DRB Application No.: 05DRB-00780 (SBP)  
Project Name: OAK STREET CONDOMINIUMS  
Agent: DESIGN PLUS LLC

**TO:** Sheran Matson, DRB Chair  
**FROM:** Carmen Marrone, Senior Planner  
**RE:** Project #1003715, Oak Street Condominiums

**DRB CASE NO/PROJECT NO: 1003715**

OAK STREET CONDOMINIUMS
ALBUQUERQUE, NM
LANDSCAPE PLAN

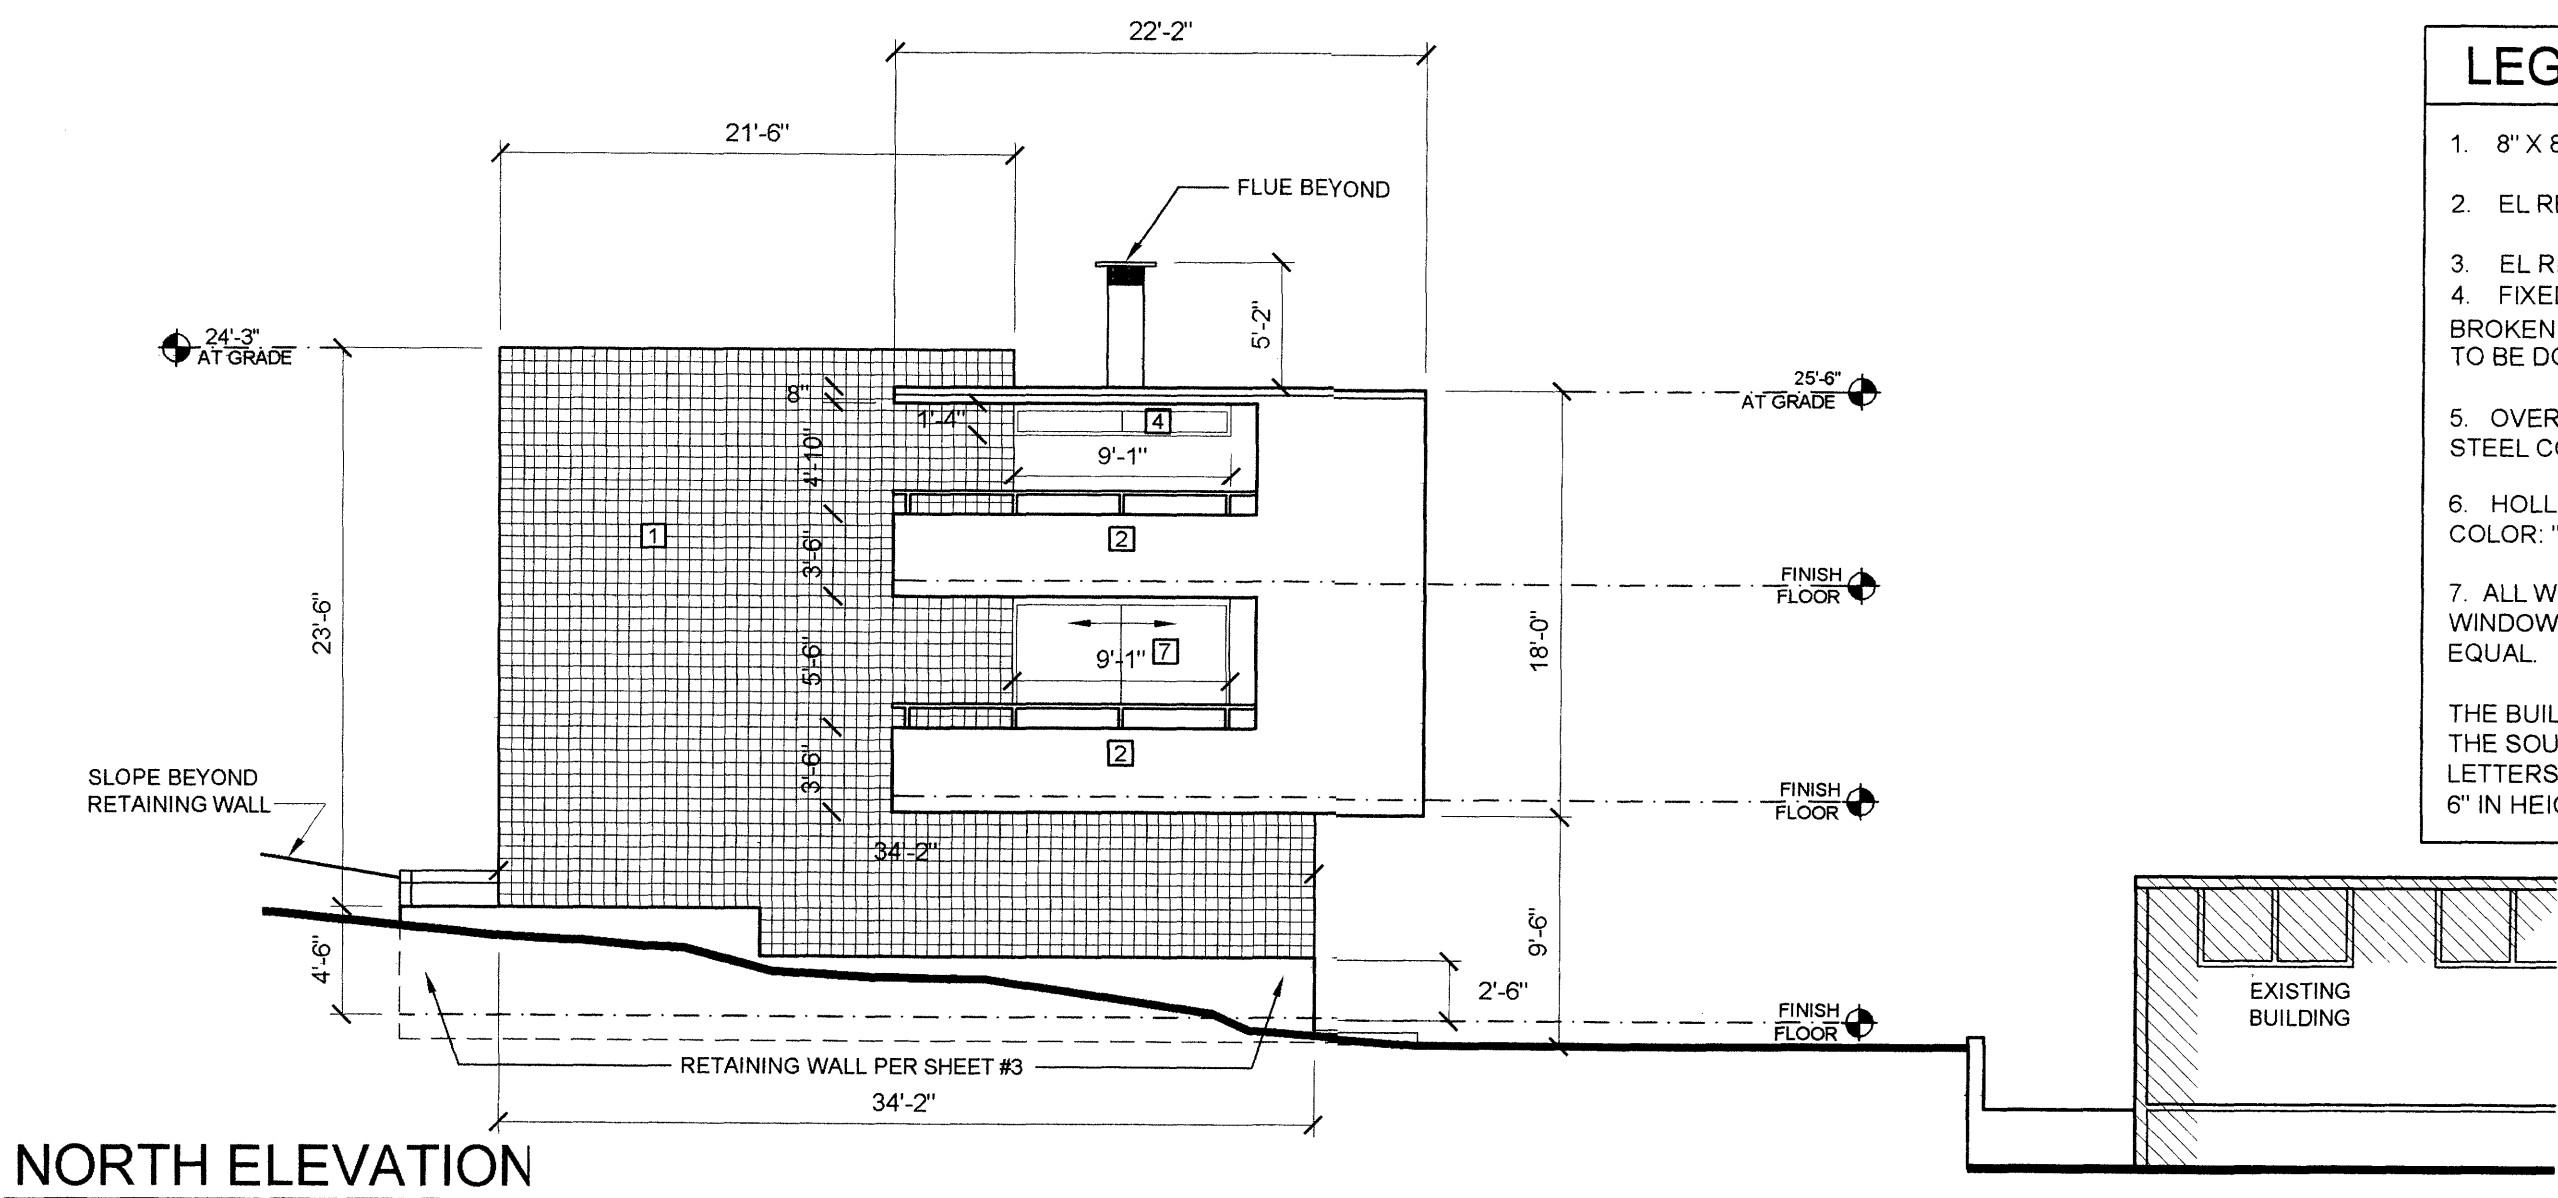
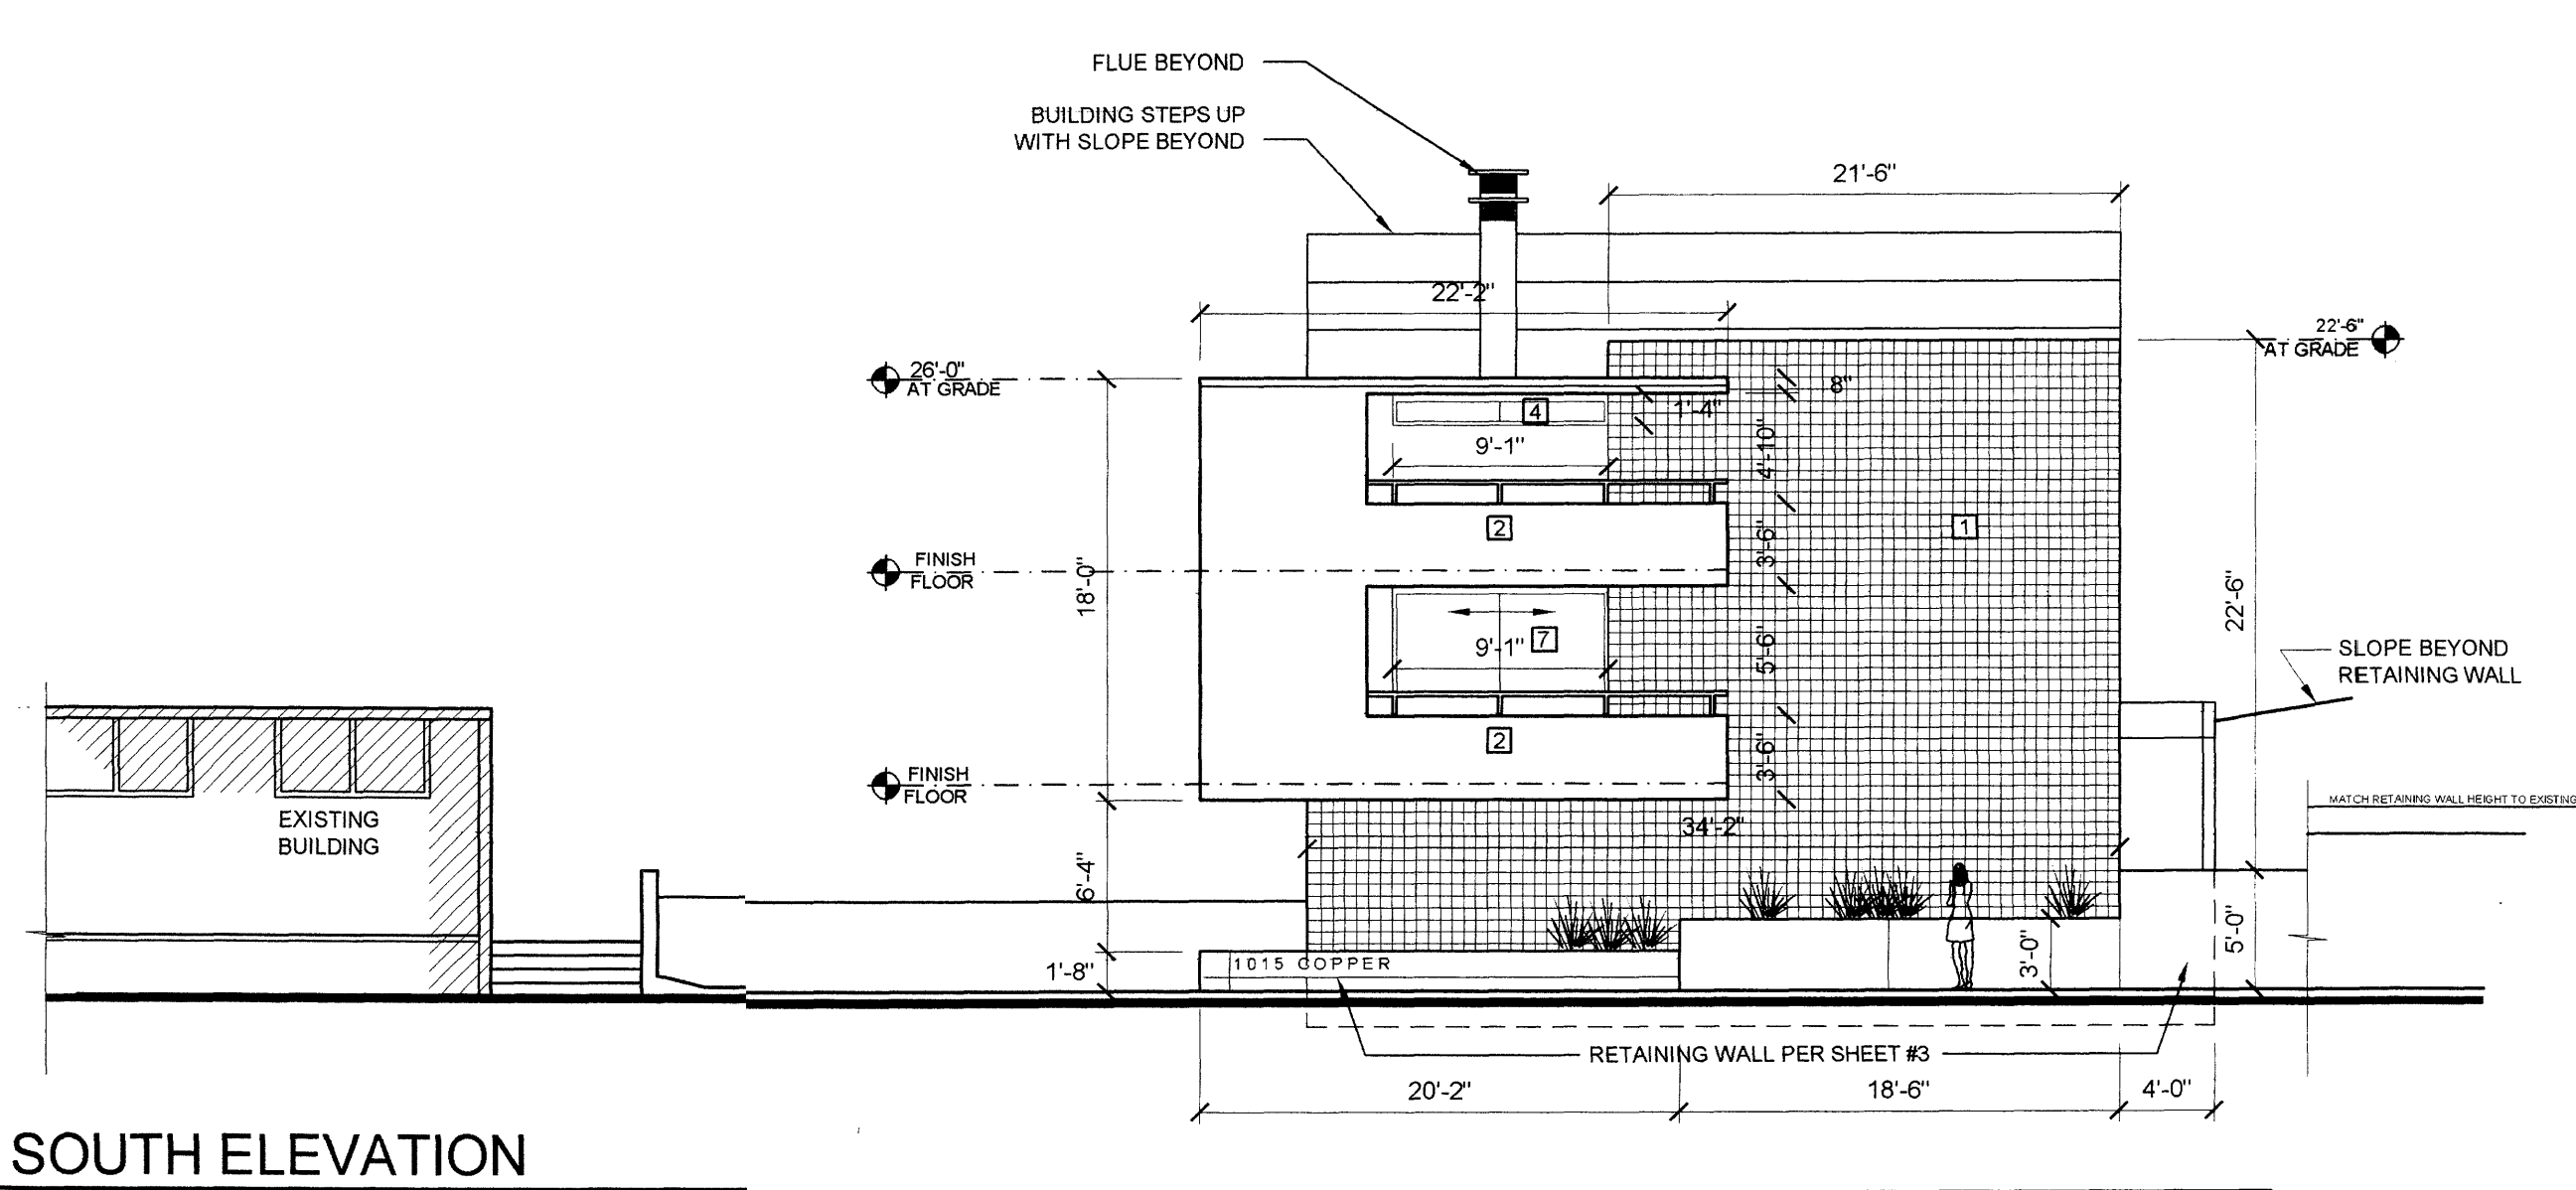
Condition 17: The site plan shows three street trees along Copper Avenue while the landscape plan shows two street trees. Revise the site plan to match the landscape plan.
